DECISION DELEGATED TO HEAD OF PLANNING

Application No:	H01-0687-22	Applicant:	J Waters & S Warren
Proposal:	Proposed detached garage & new frontage wall		
Location:	6 Stone Gate Cowbit Spalding		
Terminal Date:	7th September 2022

SITE PLAN - PROPOSED
1/250.

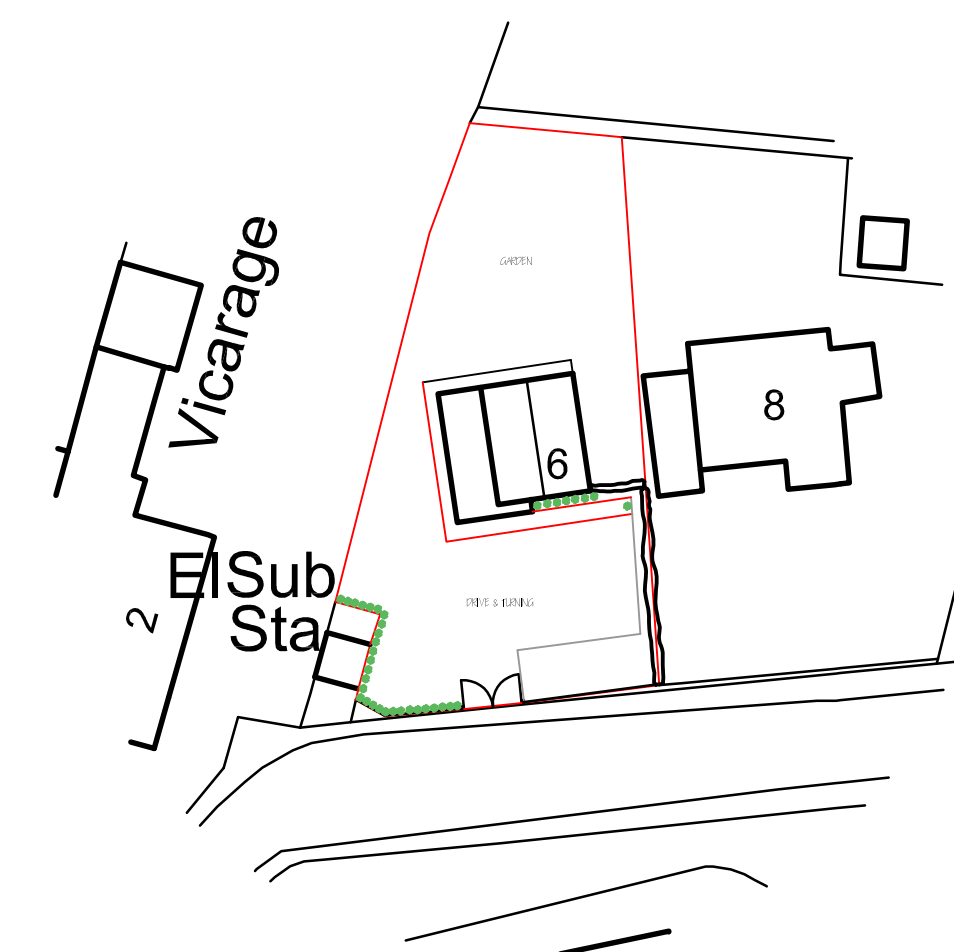
I wish to object to this proposal on conservation grounds. As a grade I listed property, the adjacent church of St Mary is amongst the very most important listed buildings in the entirety of South Holland. To erect a modern, featureless garage block on the far Southern boundary of the host property's curtilage - abutting the roadway and therefore in the closest possible proximity to the Grade I listed church would be to introduce into this specific setting a feature which is incongruous to the character of the site, and neither better reveals nor preserves the significance of the listed building, as is a requirement for all developments within the setting of a listed building, as outlined in Section A, Para. 3 of Policy 29 of the South East Lincolnshire Local Plan (2019). Furthermore, the adjacent Vicarage can easily be considered to be a non-designated heritage asset and to place a large, roadside structure in the proposed location would undoubtedly impact upon characterful views and therefore the setting of the Vicarage in its context alongside the Grade I listed church, when approaching from the East, representing a further harmful design impact upon the local character and distinctiveness.

To the west of the host property is a large portion of side land which could easily accommodate such a proposed structure in a manner which, akin to the house is drastically set back from the road, therefore, minimising the visual impact upon both the grade I listed building and the associated vicarage. I would suggest that a proposal to place the proposed on that aforementioned side land would be viewed much more favourably from a conservation perspective. However, in this proposal's current format, I must suggest that the officer refuse permission on the above grounds in addition to any other considerations deemed relevant to this case.

The proposed detached garage will be situated forward of the principle elevation of the dwelling, adjacent to the highway, and will measure approx. 5.6m by 5.4m, with the garage door opening on the north elevation. It will be constructed of facing brickwork and concrete roof tiles to match existing. A pitched roof will be formed, similar to the existing dwelling.

Concern has been raised regarding the proposed garage being at odds with the character and design of the surrounding area, and the impact it would have on designated and non-designated heritage assets. The garage would be set forward of the dwelling, being sited adjacent to the highway. There are no other instances in the immediate vicinity where garages are sited in such a location and therefore it would be at odds with the existing pattern of development in this respect. Furthermore, it is in very close proximity to the Grade I Listed church to the south and The Vicarage to the west, which can be considered a non-designated heritage asset. Policy 29, Part A, Point 3 in the SELLP, 2019 states that "Proposals that affect the setting of a Listed Building will be supported where they preserve or better reveal the significance of the Listed Building". In this case, it does not appear that the proposal would have a positive affect upon preserving or would better reveal the significance of the Listed Building. Rather it would introduce a bland and featureless building in close proximity. Furthermore, it would impact on views of a non-designated heritage asset (The Vicarage) to the west when viewed from the east along Stone Gate. The application is not supported by a Heritage Impact Assessment.

In light of the above, the proposal is considered to be at odds with the surrounding character of the area and will be detrimental to designated and non-designated heritage assets. It is therefore deemed to be contrary to Policies 2, 3 and 29 in the SELLP, 2019 and Sections 12 and 16 in the NPPF, 2021 in visual terms.

GROUND FLOOR PLAN.

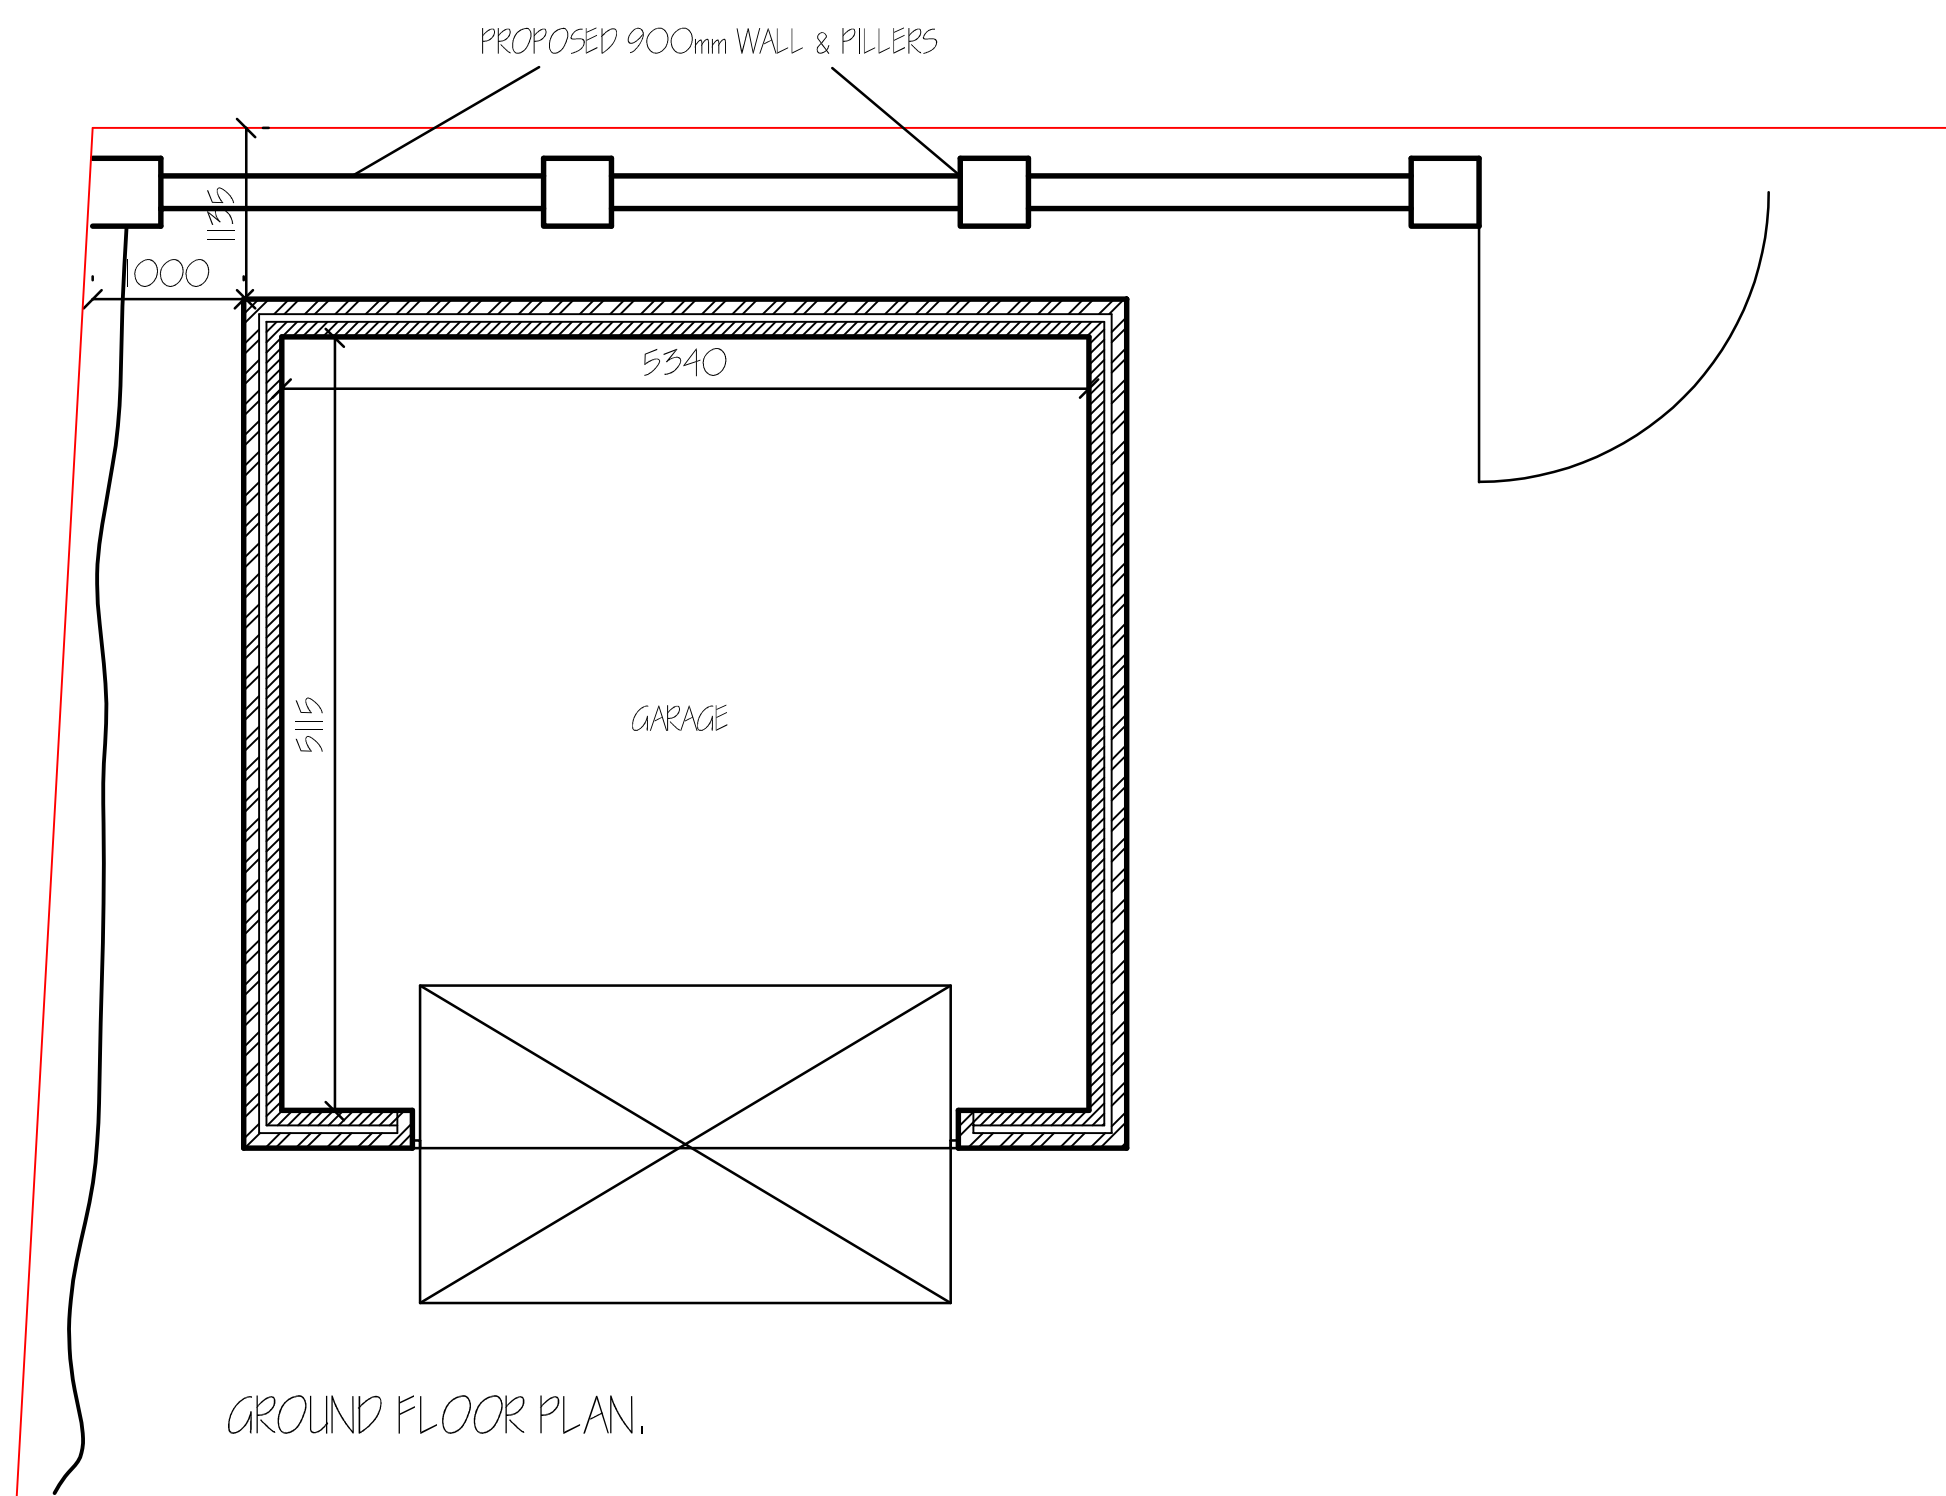
Public comments include concerns over windows being included. It is confirmed through the submitted plans that there are no windows proposed to the elevations of the detached garage, apart from a garage door which faces the principal elevation of the dwelling.
